MCLAREN TRAFFIC ENGINEERING

27th October 2021

Reference: 190133.02FB

LETTER OF RESPONSE TO DEPARTMENT OF PLANNING & TfNSW FOR THE PROPOSED EASTERN CREEK RESOURCE RECOVERY FACILITY AT HONEYCOMB DRIVE, EASTERN CREEK

Title
 Site Plan
 Resource Recovery Facility
 Lot 3, 4 & 5 DP 1225803
 Hanson Place, Eastern Creek
 Alex Fraser Group

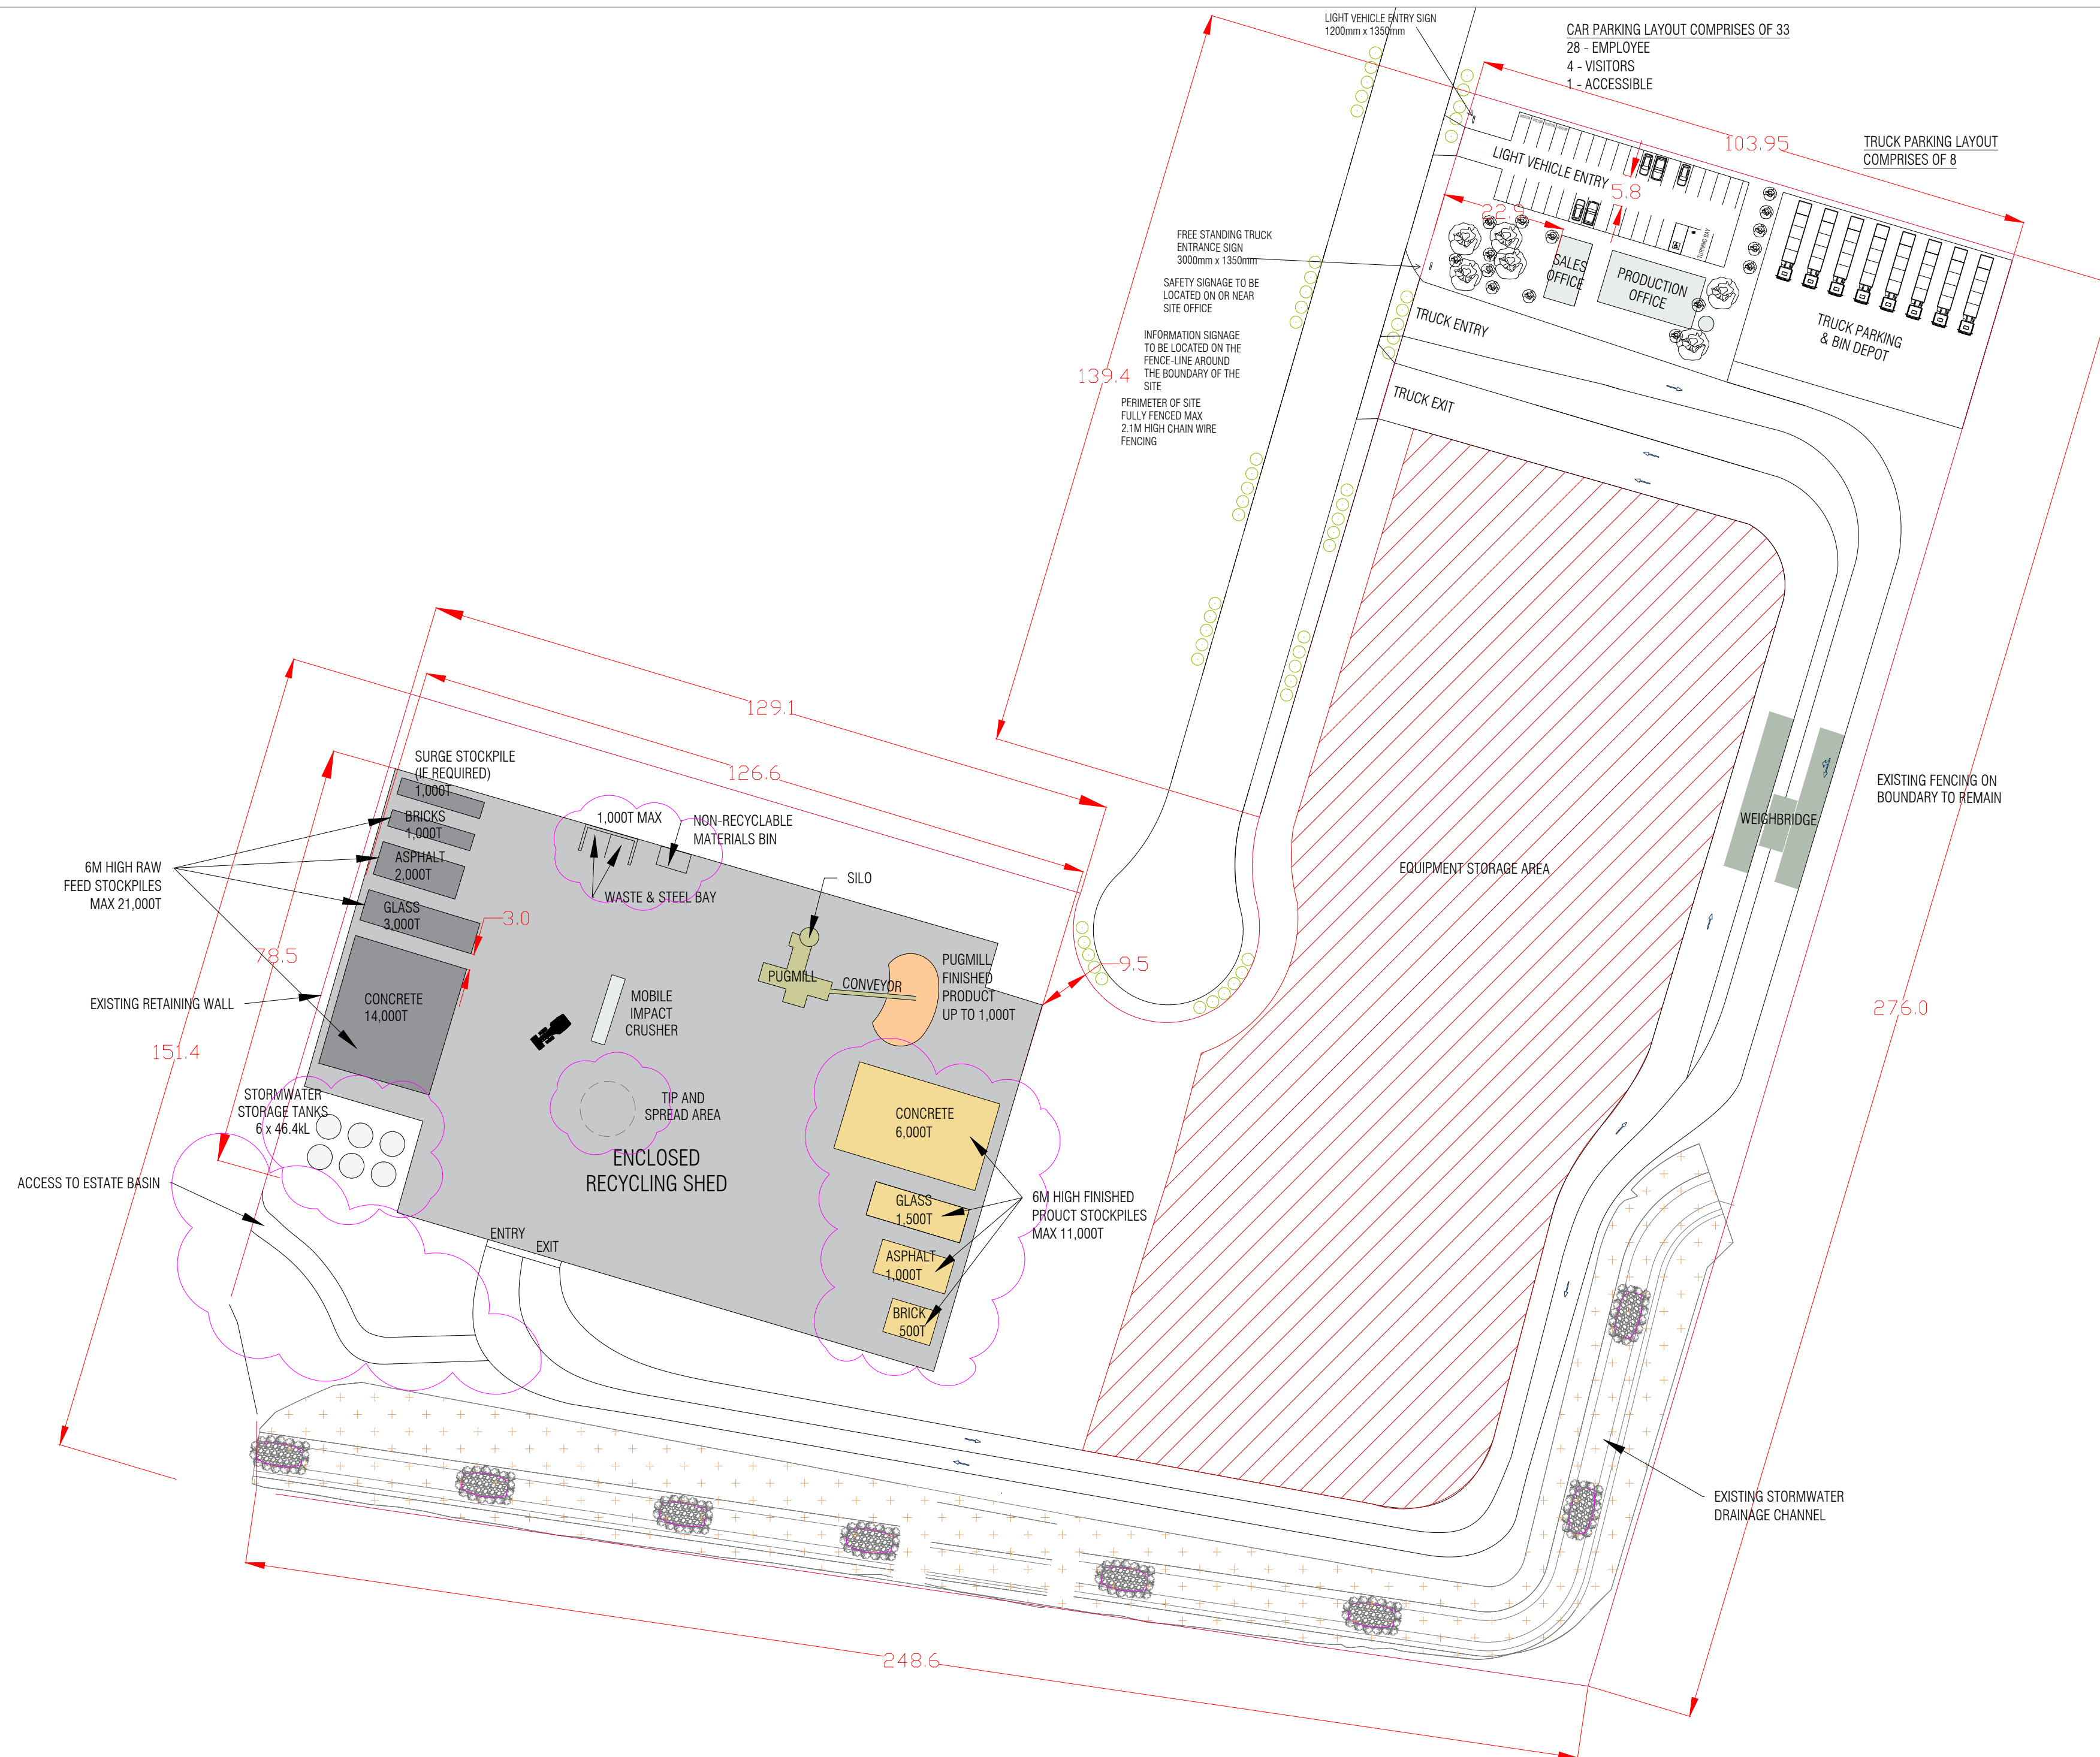
- *Provide swept path diagrams that show the largest vehicles can:*
 - *Safely pass while travelling around the site*
 - *Enter and exit the truck parking safely*
 - *Enter and exit the shed to receive and dispatch materials*
- *Describe how traffic would be controlled to effectively manage vehicles entering and exiting the site.*

The only area that does not provide internal two-way passing is the south-east corner. Whilst this is the case, the operation is still deemed safe, as intervisibility is provided between passing areas.

MTE Response: How the site manages its on-site heavy vehicle traffic entering and exiting the site is outside the scope of MTE's expertise, as we are not operators of Resource Recovery Facilities. This is for others to address. Regarding the relevant swept path testing, refer to **Annexure B**, demonstrating all requested movements.

Heavy vehicle sight distance measures as 2.5m from the ground, as such vehicles can see opposing vehicles and act accordingly, i.e., wait to give-way to opposing vehicles prior to the bend. In addition, on-site management can ensure that the operation of the site does not result in large vehicle opposing each other at this location, via a Plan of Management. Alternatively, to the above the road corner is to be widened to allow for two-way passing at all times.
